DECISION DELEGATED TO DEVELOPMENT MANAGER

Application No: H14-0454-21 **Applicant:** Mr & Mrs W Lunn

Proposal: Proposed extension and alterations - approved under H14-0090-21. Amendments to external materials.

Location: Rosecott Farm Dozens Bank West Pinchbeck

REAR ELEVATION.

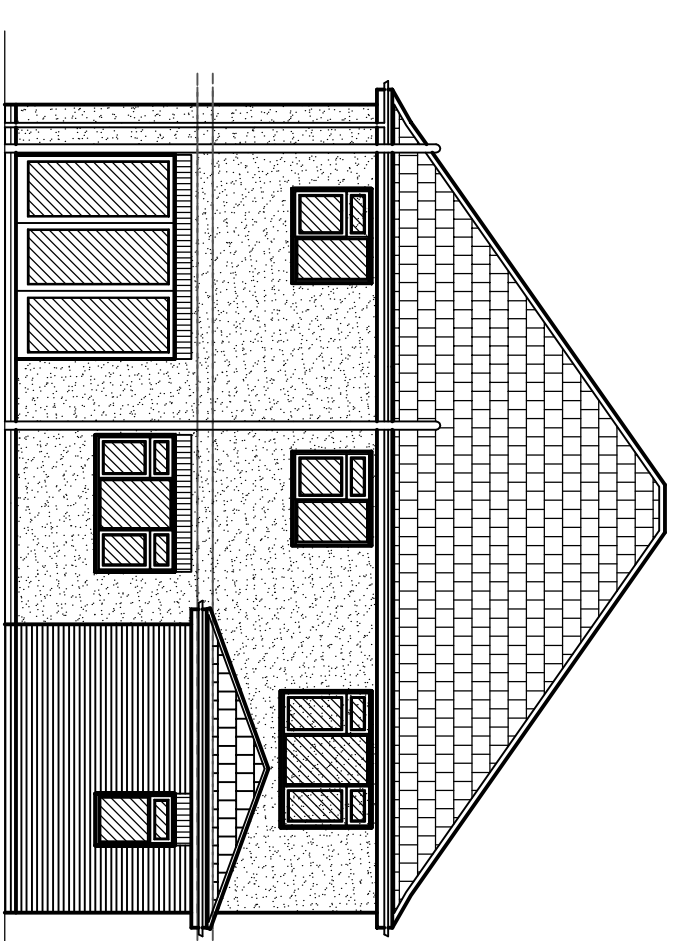
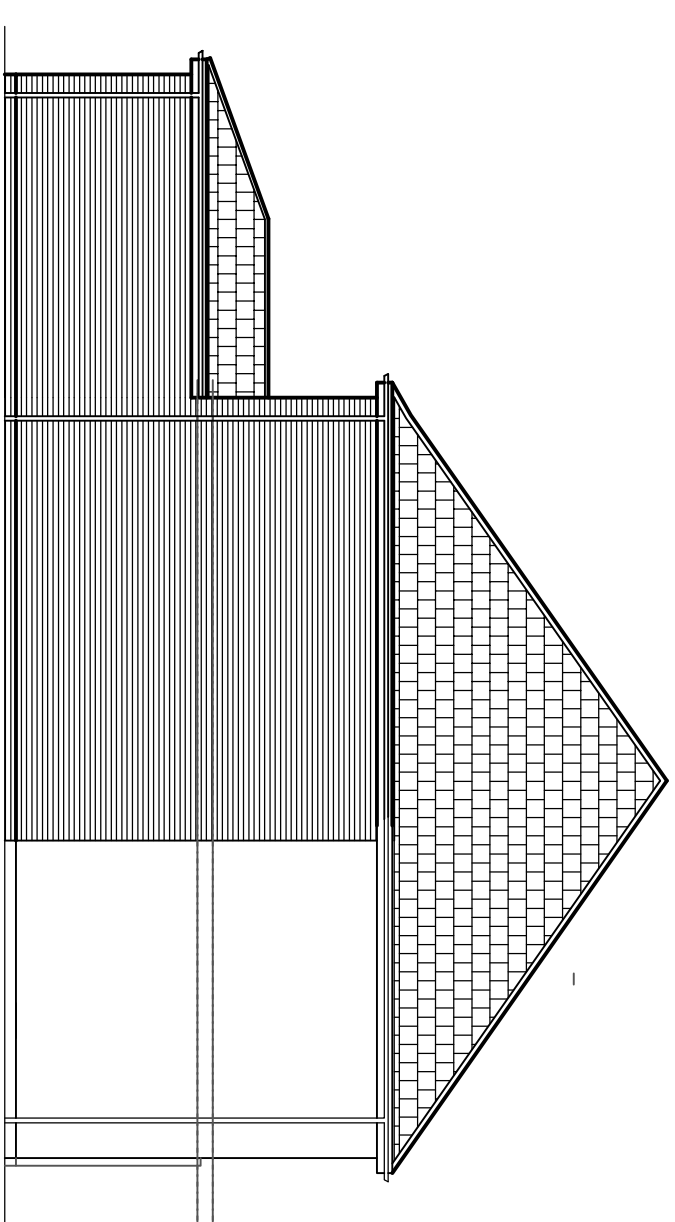
6. There would be no height increase to the building;
7. No potential overlooking issues would arise;
8. The proposal is for the rear elevation and part of the south facing side elevation to be rendered rather than brick. Given that the property is set back from the road it is unlikely this will materially alter the overall appearance of the development. The roof tiles to the main dwelling could be changed without requiring planning permission and the proposal ensures the extension will match the main dwelling;
